PLANNING DEPARTMENT – Development Review Services

September 30, 2016

**RE: Albuquerque Biopark Zoo Penguin Exhibit
Grading & Drainage Plan
Engineer's Stamp Date 9-15-2016 (File: K13D034G)**

CG-102

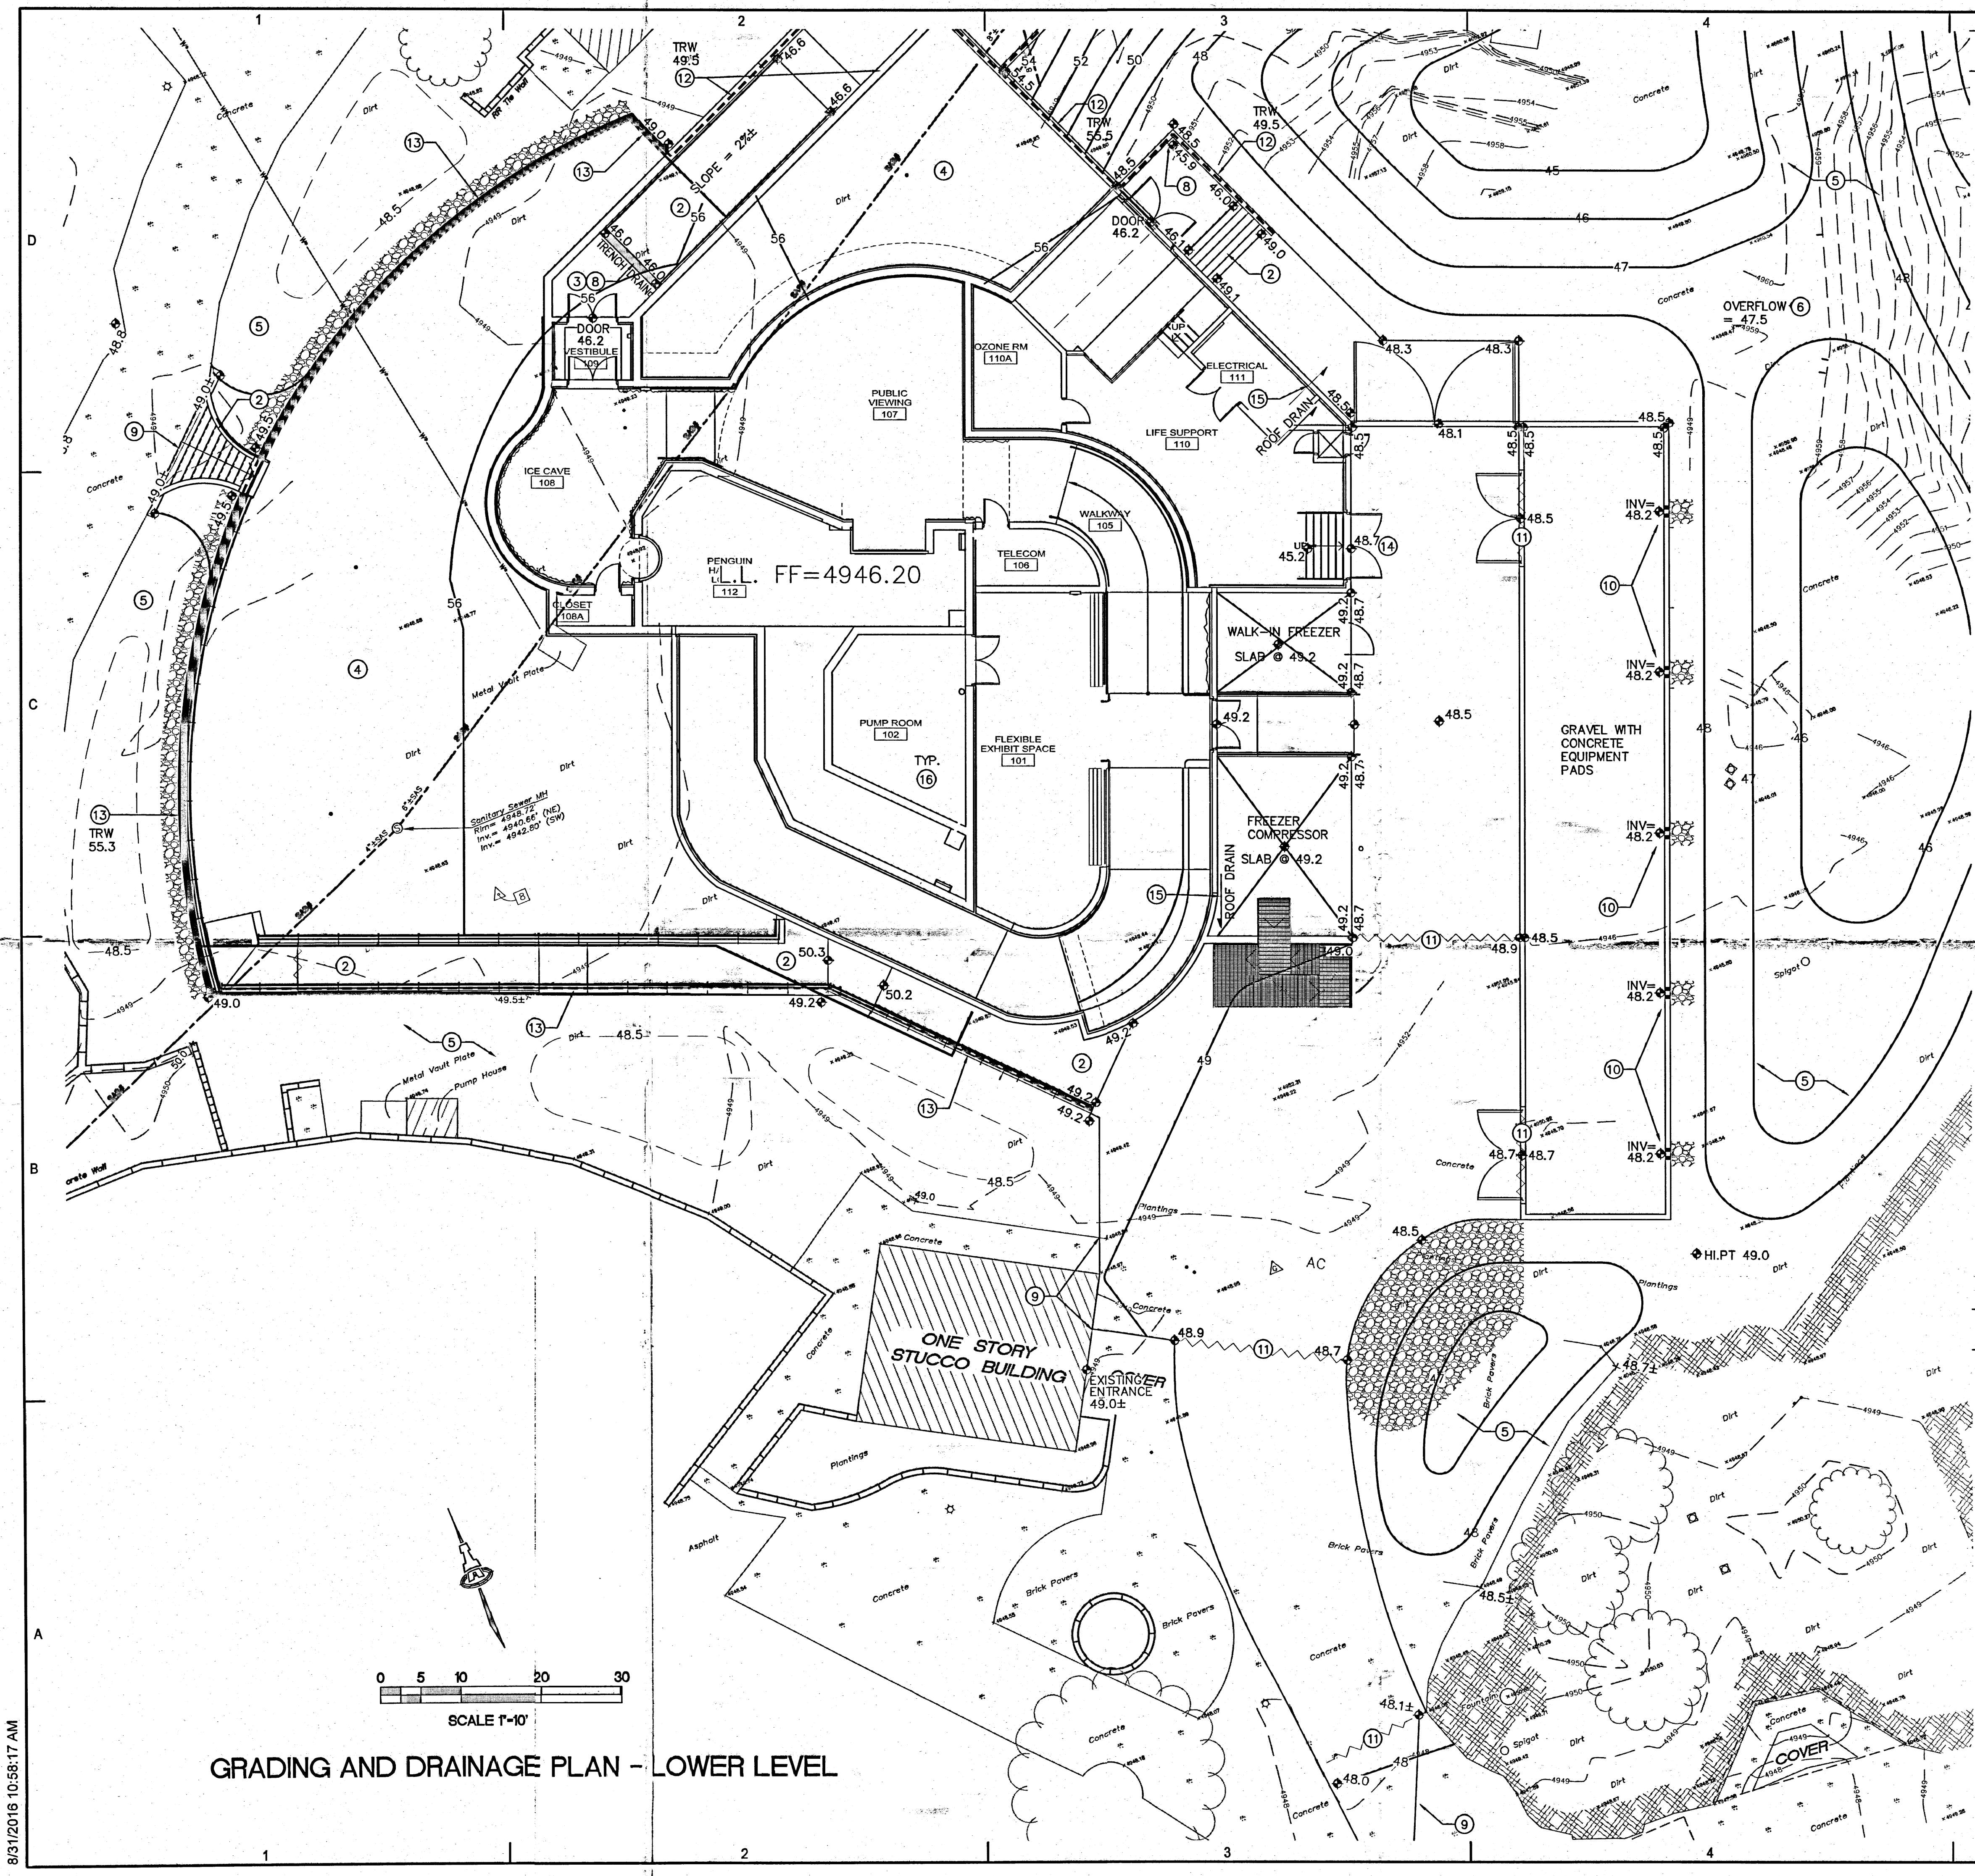
5. Provide a basin map.
6. Contact Jane Rael (505-289-3439) at the WUA to verify that they will in fact accept drainage from the trench drain into the sanitary sewer. If so, ensure that the plumbing sheets show a pipe tied to the trench drain. Provide the Plumbing sheet. (11x17 only)

7. Provide Sections showing how the building relates to the site. Include the open mechanical area in the section.
8. Define the surface materials particularly the area on the east side of the building.
